Sizewell C (SZC)

Planning Inspectorate Reference: *EN010012*

Deadline 7 – 3 September 2021

East Suffolk Council comments on Deadline 6 submissions from the Applicant

**Plate 1.19: Indicative lighting model for southern edge of temporary construction area, Kenton Hills**

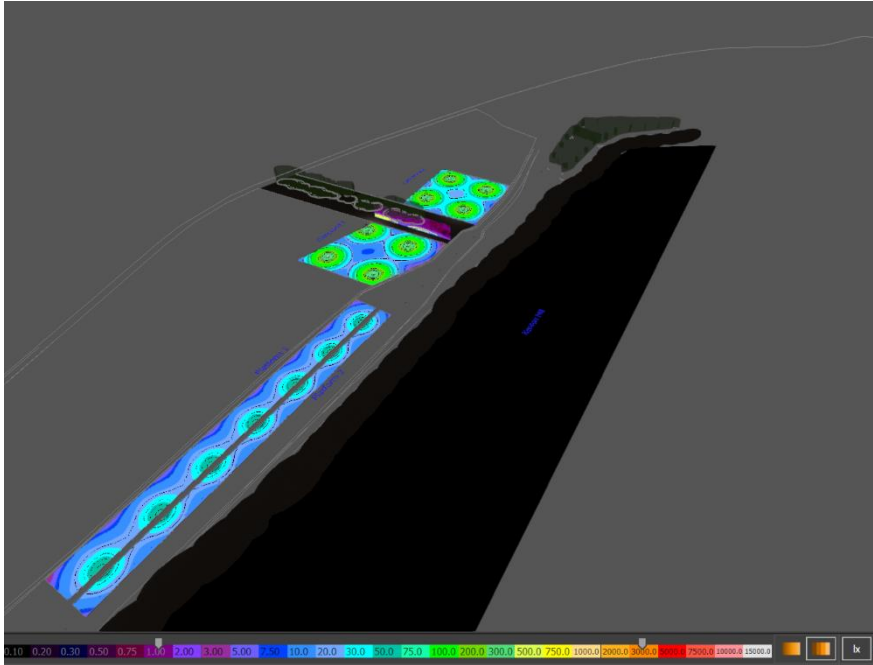
<p>With regard to construction noise, we understand that the Applicant is undertaking additional work on this matter and that it is intended to update the Code of Construction Practice to include additional controls and thresholds for construction noise in relation to ecological impacts. As with lighting, ESC will provide further comment on the revised CoCP at the next appropriate Deadline following submission.</p>	
52	2.7	<i>Point 6.</i>	<p>ESC welcomes the production of plans showing the combined noise and lighting modelling overlays as an attempt to identify areas where construction noise and lighting may cause an in-combination impact on bats, including impacting on the proposed retained/created dark corridors. However, it is disappointing that the figures (e.g. Plate 1) are presented at such a small scale in the report which has made it more difficult to interpret the information which they are presenting.</p> <p>From the information presented, it appears that the combined impacts of construction noise and light above the identified thresholds has the potential to occur in a number of locations, including on Bridleway 19 south of Upper Abbey Farm, at the SSSI Crossing and along the southern boundary of Ash Wood. ESC understands that the modelling used to produce these figures is necessarily of a relatively broad scale (particularly for noise) and that real world effects will likely be lower than those presented in the models (so the models present a precautionary situation). However, it is clear, based on the information presented to date, that the potential for adverse</p>	<p>Updated CoCP and Lighting Management Plan documents submitted for review and comment. Removal of construction lighting proposed in the area immediately to the south of Ash Wood.</p>

<p>impacts on bats from construction noise and lighting exists at certain points within the Temporary Construction Area and the Main Development Site and therefore measures to adequately reduce these impacts are required to be secured by the DCO. ESC considers that these must be secured by the CoCP and Lighting Management Plan, both of which at this time do not include adequate controls. ESC understands that the Applicant is seeking to address these points through submission of updated CoCP and Lighting Management Plan documents. ESC will provide further comment on these when they are available.</p> <p>We also maintain our opinion that, notwithstanding the incidental mitigation of lighting impacts south of Ash Wood that will occur as a result of the proposed acoustic barrier fencing (para. 2.7.2), lighting in this location should be avoided to ensure that there is no potential for adverse impacts on roosting, commuting or foraging bats in and adjacent to the wood.</p>
